Proposed Residential Development (520 units) and new primary school, Land East of Chipping Lane, Longridge. LCC Transport Assessment Comments on submitted TA by Vectos

These notes are based on the Transport Assessment (TA) dated August 2014 and associated documentation submitted by Vectos in relation to the proposed development of 520 dwellings which incorporates the relocation of Longridge Cricket Club and a new primary school. These notes will follow the layout of the TA and will use the section titles and paragraph numbering from the TA.

DRAWING NO:  
**VN30277-G302**

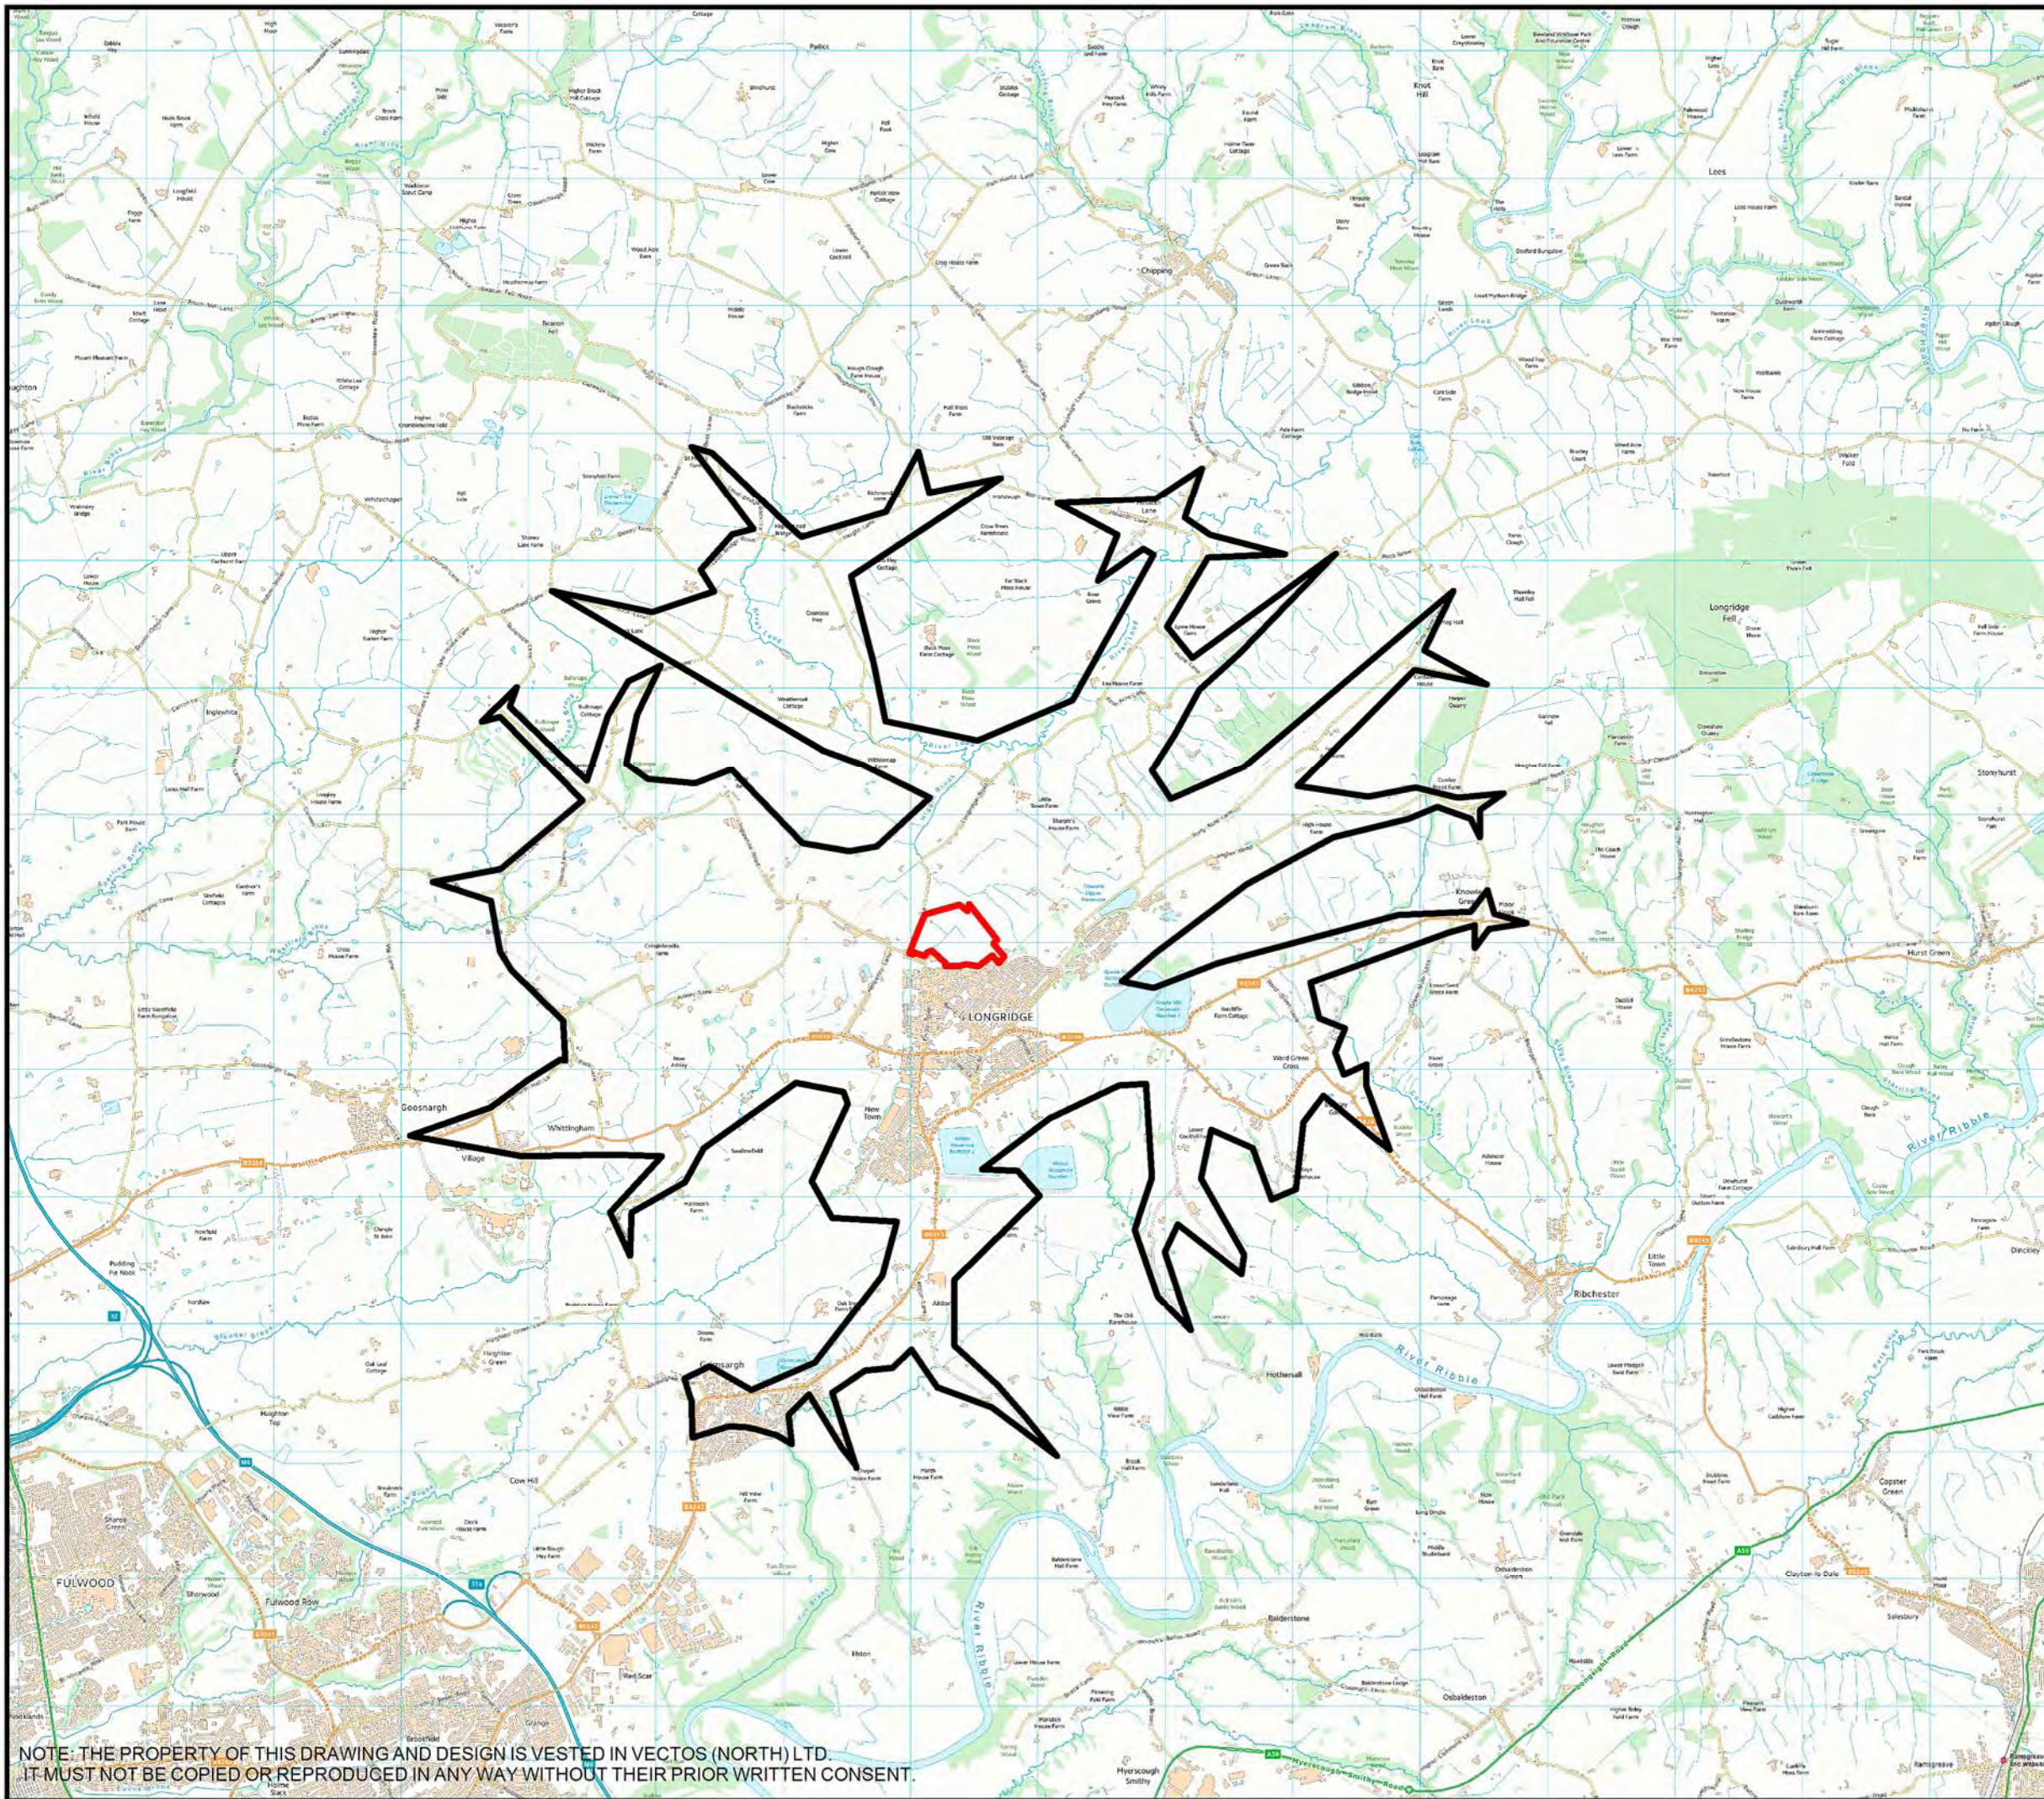
4.3.6 The submitted walk catchment (Plan 9) is misleading as it is projected from the boundary of the site. The catchment should be taken from the centre of the site.
